**Deadline 6 Submission
for
The Royal Society for the Protection of Birds**

**Application by SMartWind for an Order granting Development Consent for the
Hornsea Offshore Wind Farm – Project Two**

**Planning Inspectorate Ref: EN010053
Registration Identification Ref: 10031166**

The RSPB's response to the Applicant's Response to Deadline 5

**Figure 1. Proportions of kittiwakes recorded at Potential Collision Height (PCH) (as % of all kittiwakes recorded at the site)**

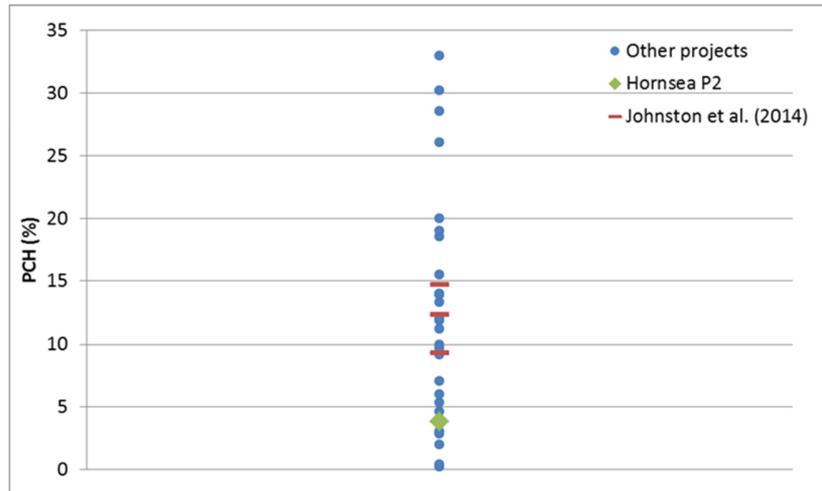
8. The RSPB maintains its position that the flight height data collected by the Applicant are not of a suitable resolution for use with the Band extended model (Option 4), and since the height data given (as summarised by the Potential Collision Height (PCH) value) lie outwith the confidence intervals presented in Johnston *et al* (2014) for several species, these data cannot be relied upon for the basic model, Option 1 either.

9. In order to attempt to explain the very low flight heights recorded at surveys for Hornsea Project 2, the Applicant presented a review of kittiwake flight height data estimated at other proposed developments, in Table 1.5 of Appendix DD of its Deadline 4 response. The RSPB provided some criticism of this in their Oral Submissions (*Summary of oral case from Issue Specific Hearing 15 & 16 September 2015, Submitted for Deadline 3*, p7, para 8.4.3 b and c) and Natural England have also provided a critique, in their Written Submission to Deadline 5, paras 3.38 to 3.40. The RSPB agree with NE's critique. In the Applicant's Appendix G submitted for Deadline 5, it responds to some of the RSPB criticisms in paras 8.12 and 8.13, with regard to the missing sites not included within its original review despite data being available for those sites. The Applicant suggests that East Anglia One and Three offshore wind farms were omitted because the PCH was derived from measurements from digital aerial survey, despite the Applicant including aerial data from Blyth demonstration wind farm project in its review. These data were used in collision risk modelling using the Band model and as such are directly comparable. They are also potentially of greater interest because aerial surveys are likely to provide more accurate measurements of flight height than boat based estimates as we have highlighted previously¹. The PCH data for East Anglia Three are available in that application's Preliminary Environmental Information Report², although the Applicant would appear not to have accessed this.

11. Data describing kittiwake PCH have also been presented elsewhere. From a comprehensive review of published studies, Furness *et al* (2013) predicted a PCH of 16% for kittiwake. Using offshore surveys, there are the following PCH values 9%, 4%, 10.9% and 18%, from Leopold *et al.*, 2004, Chamberlain *et al.*, 2005, Paton *et al.*, 2010 and Garthe *et al.*, 18%. In addition land based studies have presented PCH values of 10%, 11% and 0%, as set out in Day *et al.*, 2003, Rothery *et al.*, 2009 and Paton *et al.*, 2010. Data have also been recorded from other platforms, such as radar, presenting PCH values of 38% and 45% (Krijgsveld *et al.*, 2005 and 2011), and laser rangefinders recorded a PCH of 20%, (see Mendel *et al.*, 2014).

12. All these studies, alongside those presented by the Applicant, reinforce the argument of Natural England and the RSPB that the PCH recorded at Hornsea Project 2 is exceptionally low, and as such cannot be relied upon.

**Figure 2. Counts of kittiwake Apparently Occupied Nests (AON) at Bempton Cliffs. Source: JNCC**

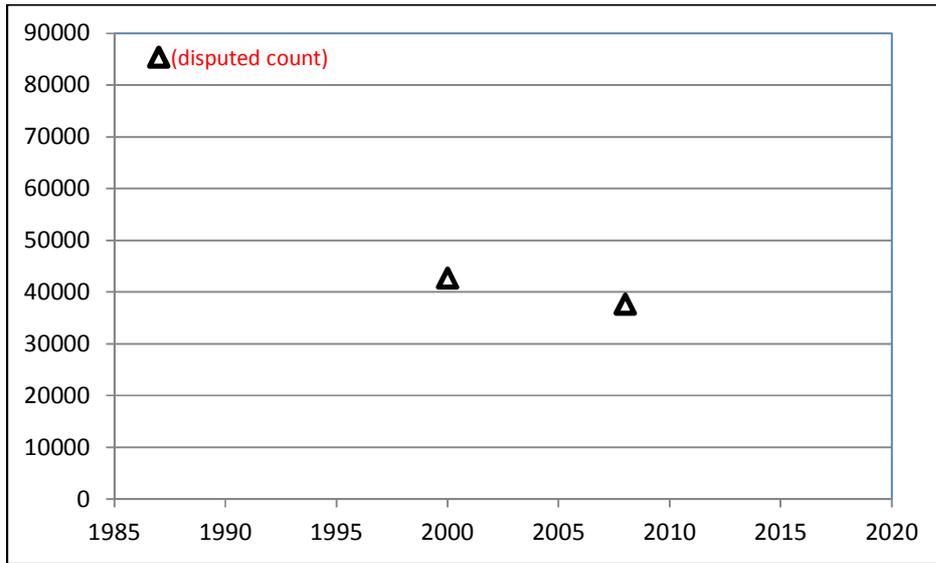
25. In the Applicant's Appendix U (submitted for Deadline 5) it has again highlighted the doubts of Dr. Coulson on the kittiwake counts carried out at Flamborough Head & Bempton Cliffs SPA in 1987. The RSPB's position (and that of Natural England) remains the same as during the Hornsea Project 1 examination (RSPB, *Comments on Responses to the Examining Authority's 2nd Written Questions and Applicant's New Information, Deadline V*), as detailed below:

3.2. The RSPB has now scrutinised the count forms for 1986 and 1987, and the relevant entries in the RSPB Bempton Cliffs Annual Reports for 1979 and 1987 (please see Appendix 2 attached). It is clear from the entries in the annual report for 1979 and 1987, as well as the count form for 1987, that the counts in these years were of pairs of kittiwakes. There was no count of kittiwakes in 1986.

3.3. In 1987, the warden carried out a comprehensive count of the Bempton Cliffs reserve “I enlisted to help of two competent volunteers to assist with the clifftop counts. We each counted a section of cliff, then swapped over, so that each section was counted at least twice by independent observers. Where our results differed by greater than 5% the section were recounted together.” In addition, counts were made from a boat. The result was 75,000 occupied nests (equivalent to pairs) of kittiwakes for the reserve recording area, Speeton Heights to Gull Nook. The overall accuracy of the count was estimated to be approximately 10%, because the boat-based count was lower than the figures obtained from the clifftop. The separate count for Flamborough Head was of 8,668 pairs (count by Mike Higgins; Keith Clarkson, Bempton Cliffs Site Manager and Roddy Mavor, JNCC Seabird Monitoring Programme, pers comms.), making a total count for the Flamborough Head & Bempton Cliffs SPA of approximately 83,668 pairs.

3.4. The RSPB Bempton Cliffs Annual Report for 1979 (Appendix 3, page 1 attached) indicates that a total of c.64,180 pairs of kittiwakes was counted and estimated for the Bempton Cliffs reserve plus c.16,000 for Flamborough Head, making a total of c.80,180 pairs of kittiwake for the SPA. This was considered at the time to compare “well with the rapid increase of this species over the rest of Britain and Ireland during recent years”. Note also that the count for 1979 was sent to John Coulson, as organiser of the 1979 British Trust for Ornithology Kittiwake Survey, at that time and cited by him in 1983: “Although this colony [Bempton – Flamborough Cliffs] is difficult to census, there can be no doubt that a large increase has taken place there during the past 20 years and that the increase probably started with the cessation of extensive egg collecting on the cliffs.” Sizeable declines were recorded for some colonies, away from the North Sea coasts, at this time, presaging further, and more widespread, declines in later years. Coulson (1983) also acknowledged that “the change in population trend has been large and rapid”.

3.5. The time elapsed since these counts makes it impossible to do more to verify the information. However, the available documentation indicates that the counts of kittiwake in the SPA citation stand. This is the position accepted by the JNCC as curator of the Seabird Monitoring Programme.”

26. This position with regard to the count data was upheld by the Secretary of State for the Hornsea Project 1 decision⁴, and is in agreement with Natural England and JNCC. The RSPB can see no justification for departing from the approach adopted by the Secretary of State in the previous decision based on both NE and JNCC’s advice. We are unaware of any new information being advanced by the Applicant and consequently respectfully request the Examiners to disregard the revival of this already determined point.
